Application: 2023/1063

Address: 177 Manchester Road, Thurlstone, Sheffield, S36 9QS

Description: Erection of 2 storey side extension to replace existing single storey attached garage to 2 storey dwelling.

Drawing Title
Existing Floor Plans

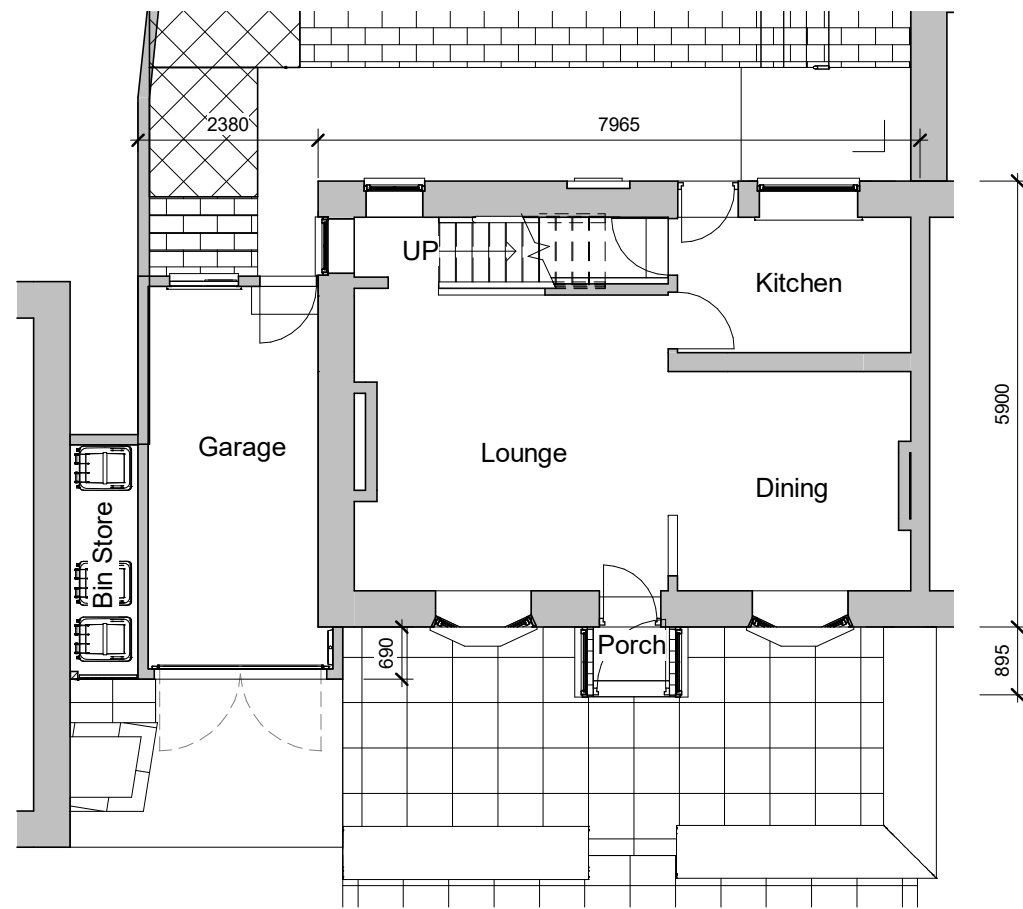
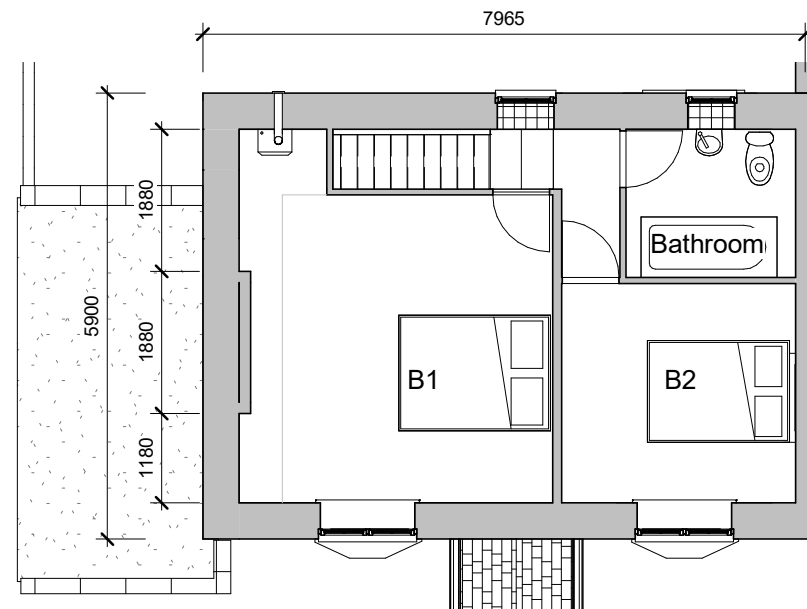
The first concern was the accuracy of the plans, particularly in relation to the boundary wall, which the commentor refer to as the party wall. Whilst it was not practical to physically measure the wall, on my site visit, I immediately noticed that the wall in question appears as is shown on the plans, this was later confirmed when viewing the wall from the rear garden. Any further dispute over the boundary would be considered a civil matter between the affected parties.

Drawing Title
Proposed Elevations

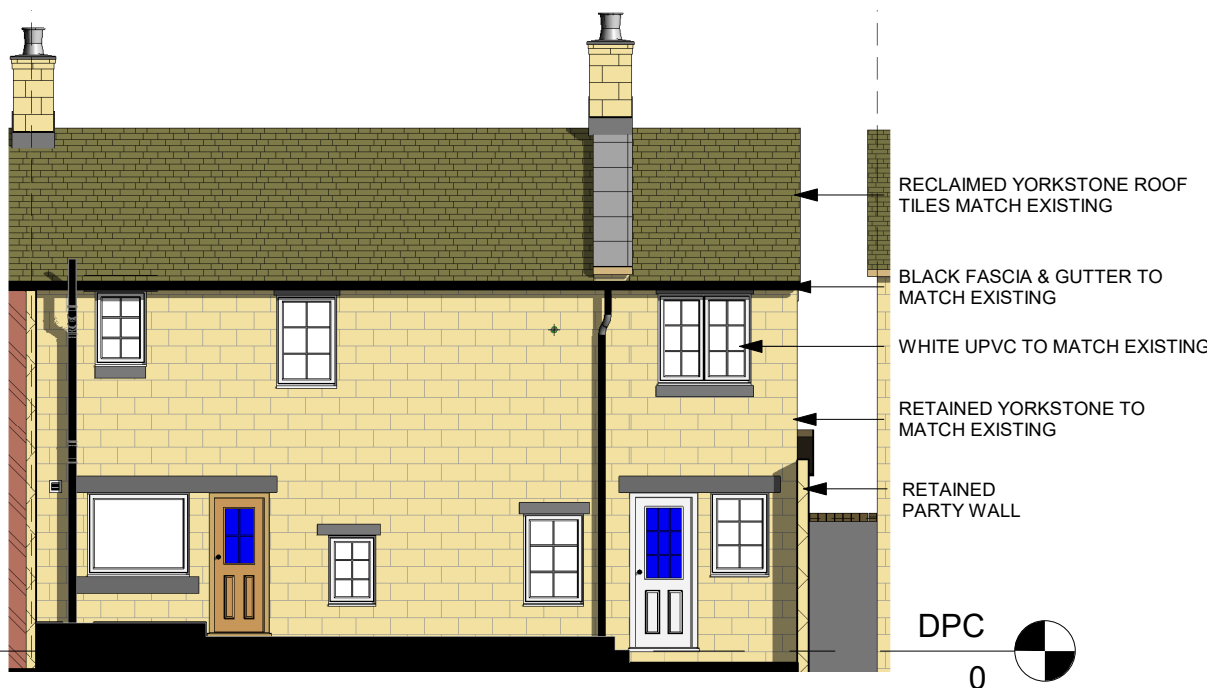
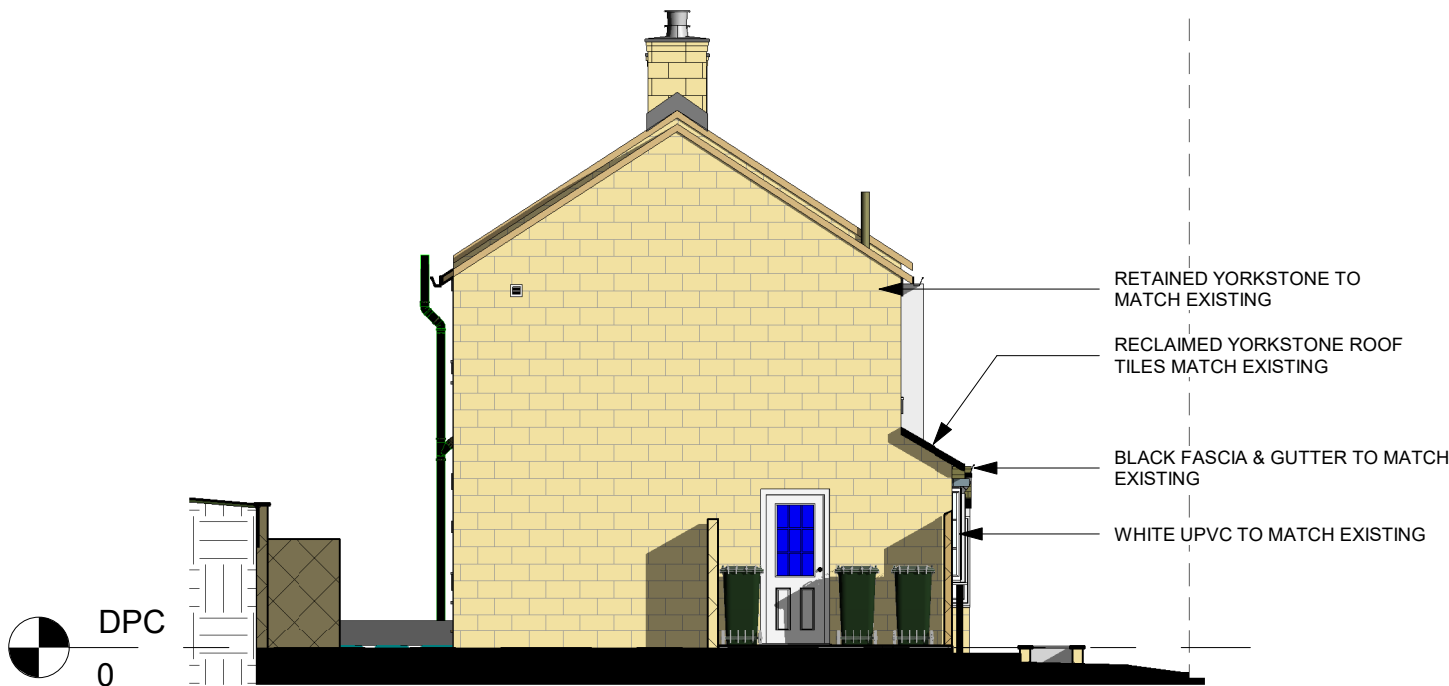
The final concern is potentially the most significant and valid concern of the objection from a planning perspective. The objection raises concerns about overshadowing and potential privacy issues. Firstly, there is a concern that the proposed extension would be at a higher level than their dwelling, due to the ground level and size of the dwelling's this is an accurate statement with the applicant's dwelling having a roof height of 7.08m, a proposed extension roof height of 6.88m and the commentor's roof height of approximately 5.9m high. The concern that the light levels within their dwelling and their solar panels may be affected. The front elevation of both dwellings are south facing, with the proposed two story extension of the western elevation. Whilst undoubtedly there would be some impact on light levels of the commentor's dwelling, utilising a basic sun calculator, light levels have the potential to be affected from early to mid-morning, with no effect from late morning onwards. In summer this potential light obstruction may start earlier but the length of no effect would be substantially longer. As such, the level of potential light loss would be minimal and should not significantly affect the overall light levels of the neighbouring dwelling.

“The proposal seeks to remove the garage and add a pitched roof extension in the form of the main dwelling. This would extend the ridge beyond the verge coping but at a slightly lower level to differentiate the extension. Windows are designed to match the existing exactly with a small bay to match the existing bay window. A short span of single pitch roof accommodates the wider footprint of the existing garage that steps forward of the house front wall. Overall, I see no issues with the design and materials that are sympathetic to the historic building and the conservation area setting. Although two storeys, I feel the proposal is more harmonious than the existing flat roofed garage and is a better fit.”

The Conservation Officer has raised no objections subject to suitable conditions. Whilst the condition requiring an obscured glazed window in the rear window of the ensuite bathroom may not be in keeping with the style of the dwelling; its purpose to protect the privacy of the neighboring dwelling would be of more concern.

Drawing Title
Proposed Floor Plans

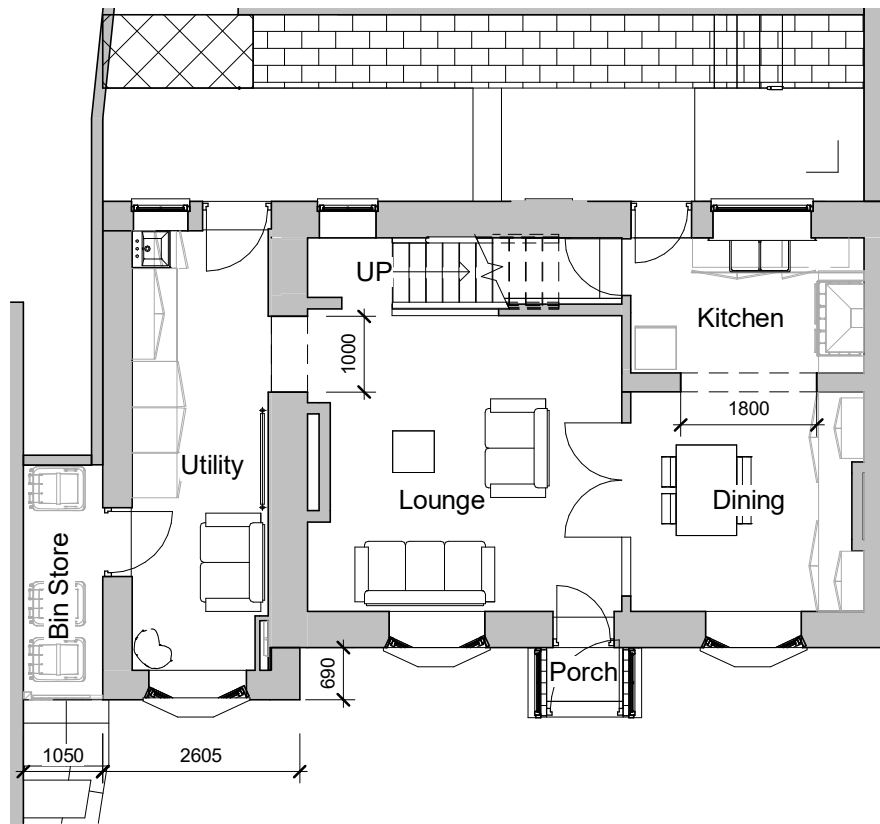
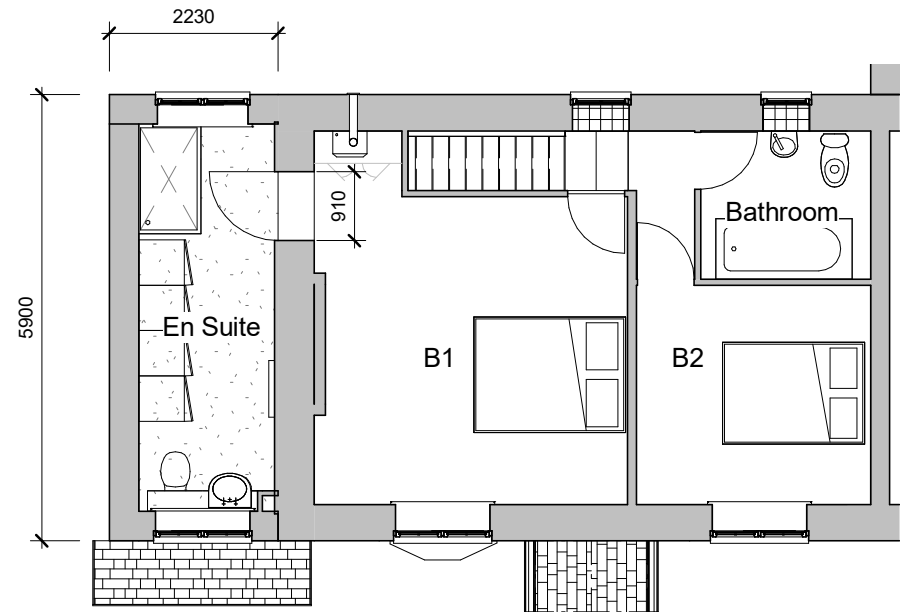
The second concern is in relation to a boundary garden wall which also currently forms part of the garage wall. On the plans, it is shown that the existing wall would be retained, or a replacement wall installed, with an extra wall being constructed inside the boundary of the application dwelling to support the two-story extension, subsequently reducing the internal space of the extension compared to the existing garage. Anything in relation to the boundary wall would be a civil matter, whilst building control would check the new wall forming the extension. Further concern was raised about the proximity of the wall to the boundary. If the wall is constructed within the confines of the application's dwelling curtilage, unless it poses harm to the residential amenity of the neighbouring dwelling, which in this instance it does not, then the wall would be permissible.

The third concern is in relation to a retaining wall, which the commentor deems necessary. From the plans provided, and from a planning perspective the plans appear acceptable with no significant

alteration beyond the rear elevation of the existing dwelling. Again, it would therefore be building control who would raise any concern about the proposal and if any retaining wall would be necessary.

In relation to privacy, the proposed front windows overlook Manchester Road and the valley beyond. The side door opens onto a blank wall elevation and the ground floor rear window and door are at a much lower level than the neighbouring dwelling and open onto a rear yard area which is enclosed by a retaining garden wall. The only potential for overlooking would be from the proposed ensuite window on the rear elevation. To eliminate this potential for overlooking, a condition would be added to the planning consent requiring that obscured glass shall be used within this specific window,
